From: Juan Baeza [REDACTED]
Sent: 16 October 2019 09:33
To: Planning.Responses [REDACTED]
Subject: EP/179/18/PL

From: Nicola Fry [REDACTED]
Sent: 15 October 2019 15:17
To: PETER SHAW [REDACTED]; Juan Baeza [REDACTED]
Cc: Jamie Brown [REDACTED]; Judie Simmonds <[REDACTED]>; Paul Beamish [REDACTED]
Subject: RE: Gladwyn - East Preston

Further to this morning's meeting at Gladwyn, The Street, East Preston, I can confirm that I am satisfied with the proposed parking provision of 9 spaces as per revised plan provided by Mr Shaw on Friday (11th October).

Project: Proposed new homes; Gladwyn, The Street, East Preston BN16 1HT			
Drawing: Block plan, bin store elevations			
For: Mrs. J. Simmonds & Mr. P. Beamish			
Drawn: PKS		Date: November 2018	
Scales: 1:50 1:200		No: 2386/01/03/C	
To scale when printed on A3

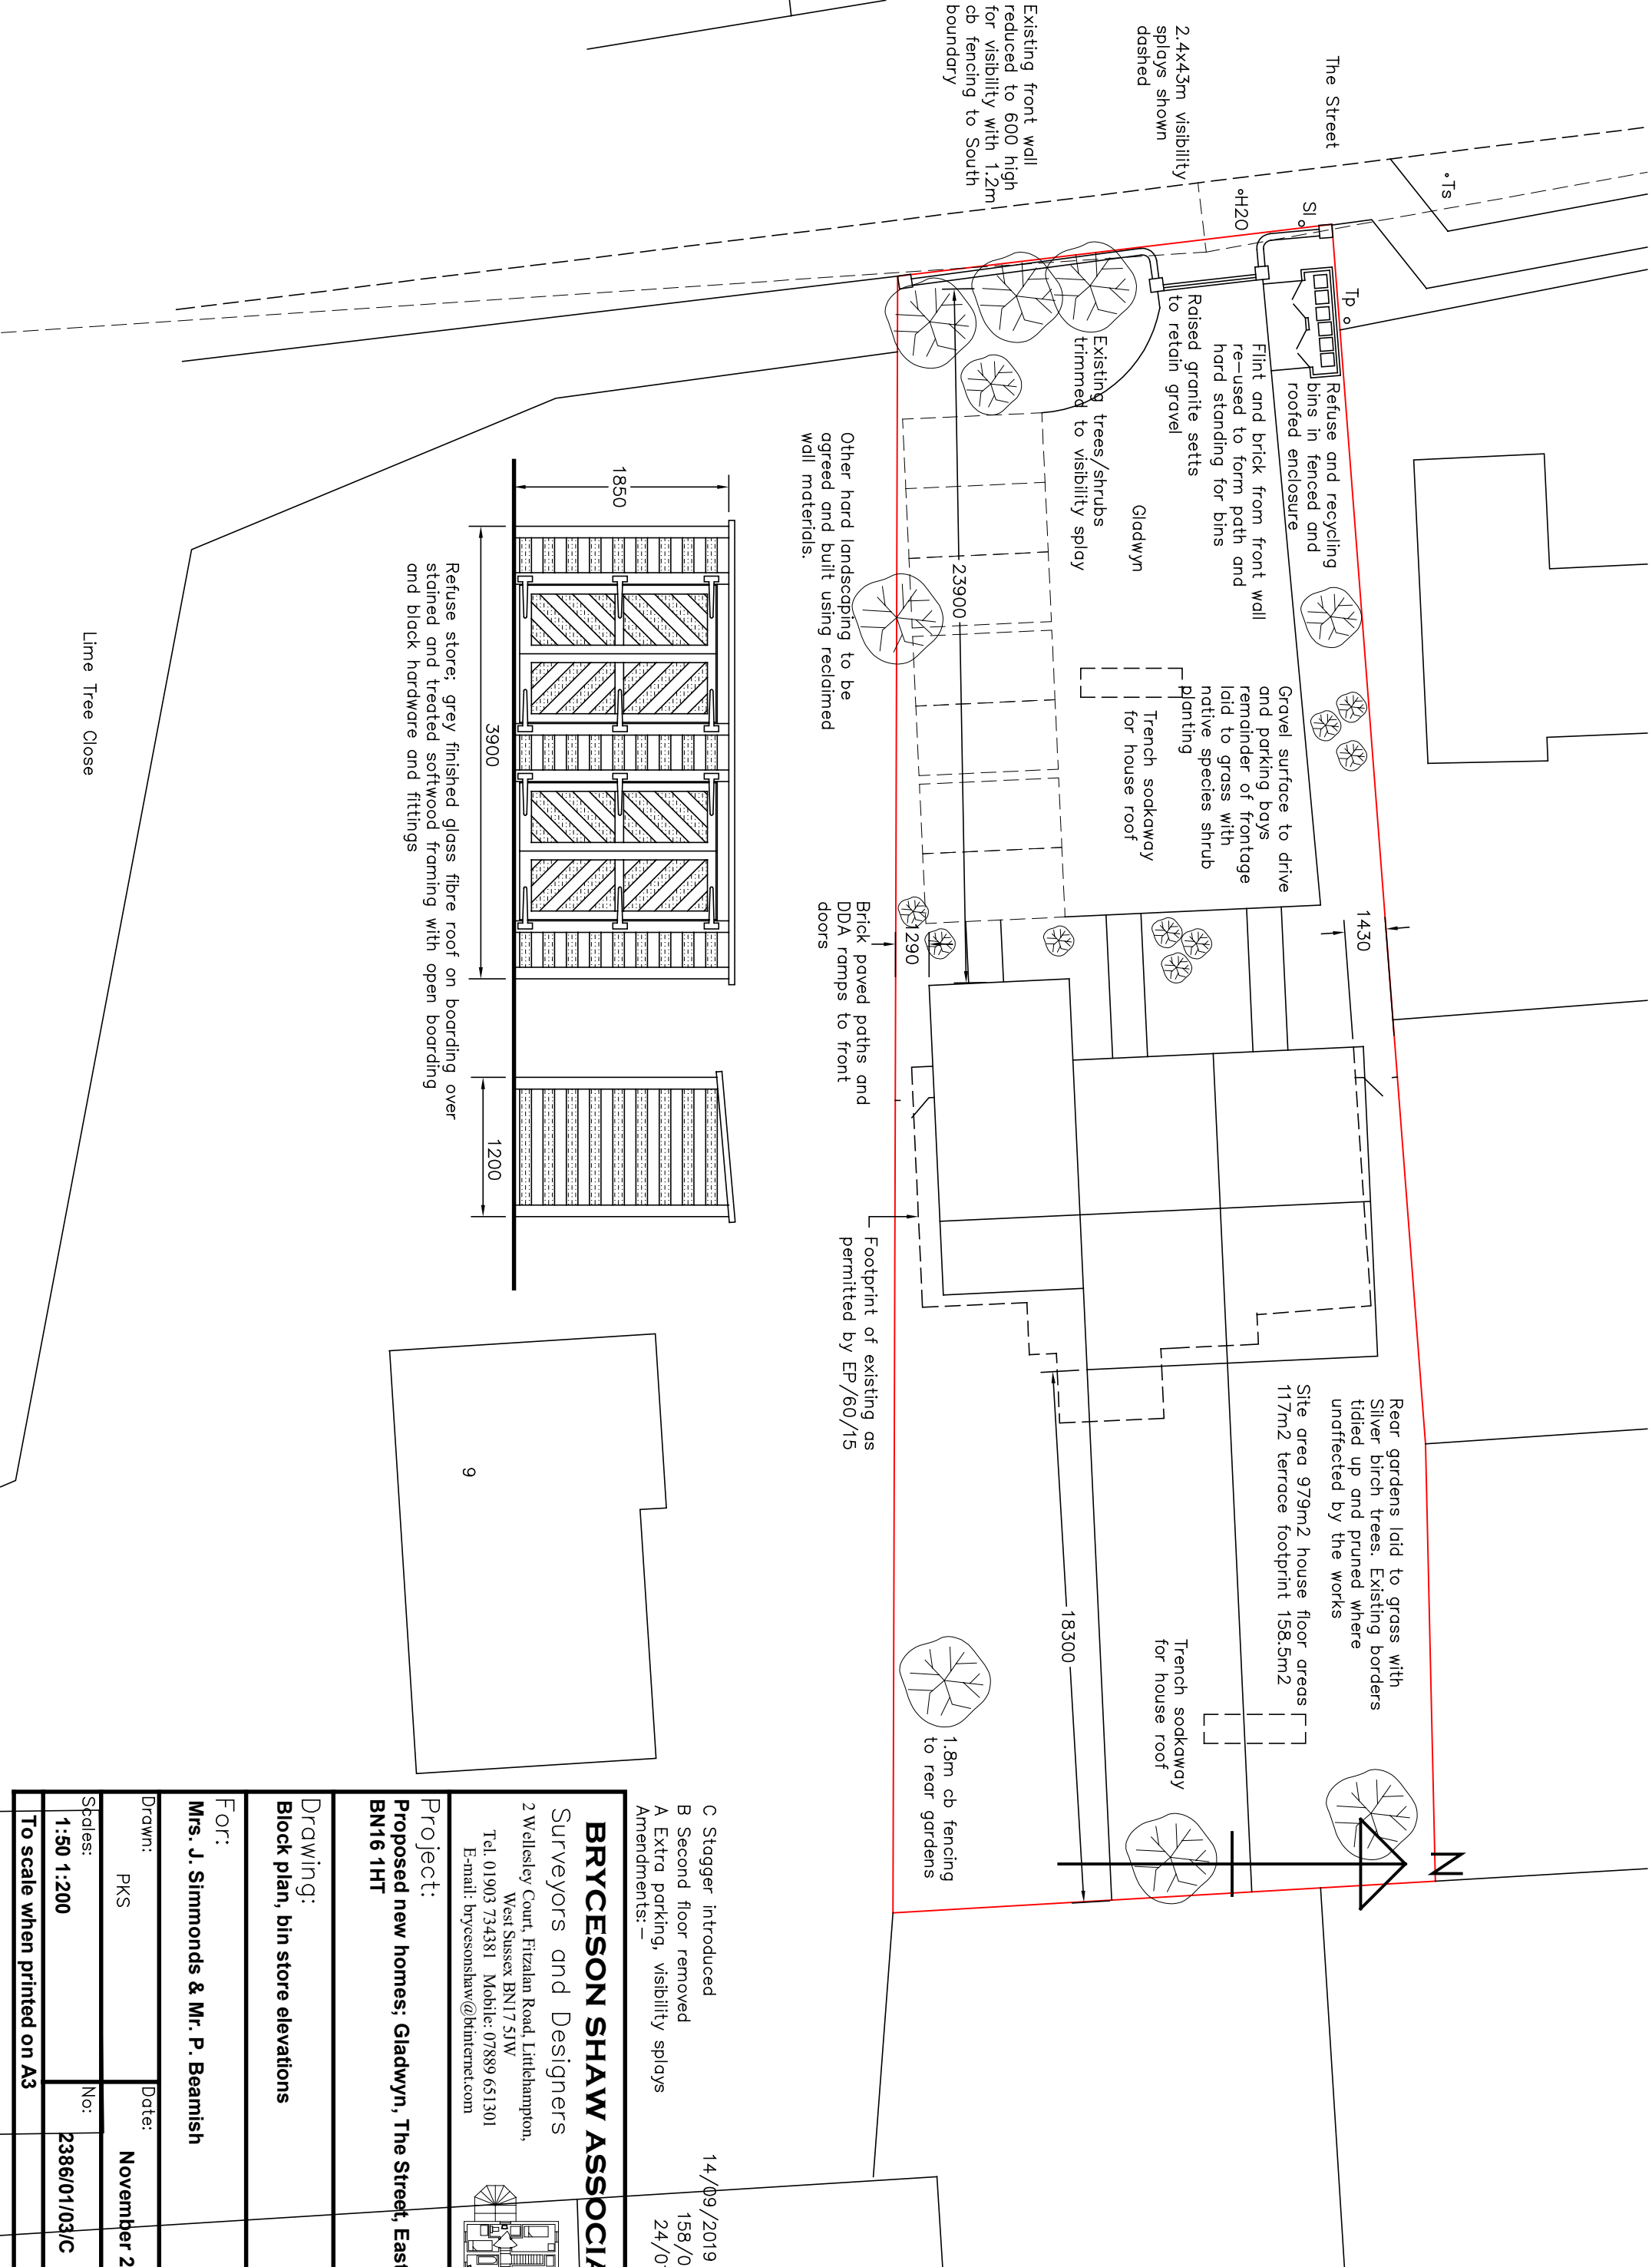
Juan, as per my previous email, I am satisfied with the proposed arrangements., and I am satisfied that the southern brick pier can remain in place as it does not impact upon the visibility splay.

As the full extent of the splays have now been demonstrated, I would recommend that this be secured via condition (details *approved*).

I should have added earlier, I would also advise conditions securing the proposed parking and turning arrangements (details approved) and secure and covered cycle storage (details required).

I can confirm that 9 spaces meets the minimum requirements for allocated parking provision, i.e. 2 spaces allocated per dwelling and 3 overspill/visitor parking spaces. I understood from Mr Shaw that he intends to retain unallocated provision, in which case, the proposed provision exceeds the minimum requirement of 7 unallocated spaces.

With regards to the boundary wall, we measured visibility on site at a distance of 2.4m back from the carriageway edge. In the leading direction (to the north of the access) 43m visibility is achievable in accordance with Manual for Streets (MfS) standards, without any alterations to the existing wall required. In the trailing direction (to the south), visibility is obstructed by the wall and overgrown hedges.

The current height of the boundary wall is 1.2m. We discussed two options on site, firstly the reduction in height of the wall, and secondly relocating the wall within the site. In its current position, due to the proximity to the school, we would require the wall to be reduced in height to 600mm to allow visibility of small children. However, we did agree on site that a compromise could be reached and we would support the wall being reduced in height to 800mm. This option would still result in some loss of the wall. We then discussed the option of repositioning the wall to a set-back of 0.5m from its current position. It was agreed by all that this would be the favoured option as it is anticipated to provide a full unobstructed visibility splay of 43m to the south and would not result in any loss of the flint wall.

Subject to a revised plan confirming that a 0.5m set-back would provide the required 43m splay to the south, I would not consider that this proposal would have an unacceptable impact on highway safety or result in 'severe' cumulative impacts on the operation of the highway network, therefore is not contrary to the National Planning Policy Framework (paragraph 109), and that there are no transport grounds to resist the proposal.

Thank you for the meeting today and for your help. Please see the attached revised drawing showing the garden wall rebuilt some 500mm into the garden.

I would like to retain the Southern most brick pier as it defines the 2 boundaries of the plot and should not affect visibility. The final decision on this can be made once we start site clearance and can properly set things out.

I have plotted the drawing on A2 paper so the extent of the visibility splays is clear.
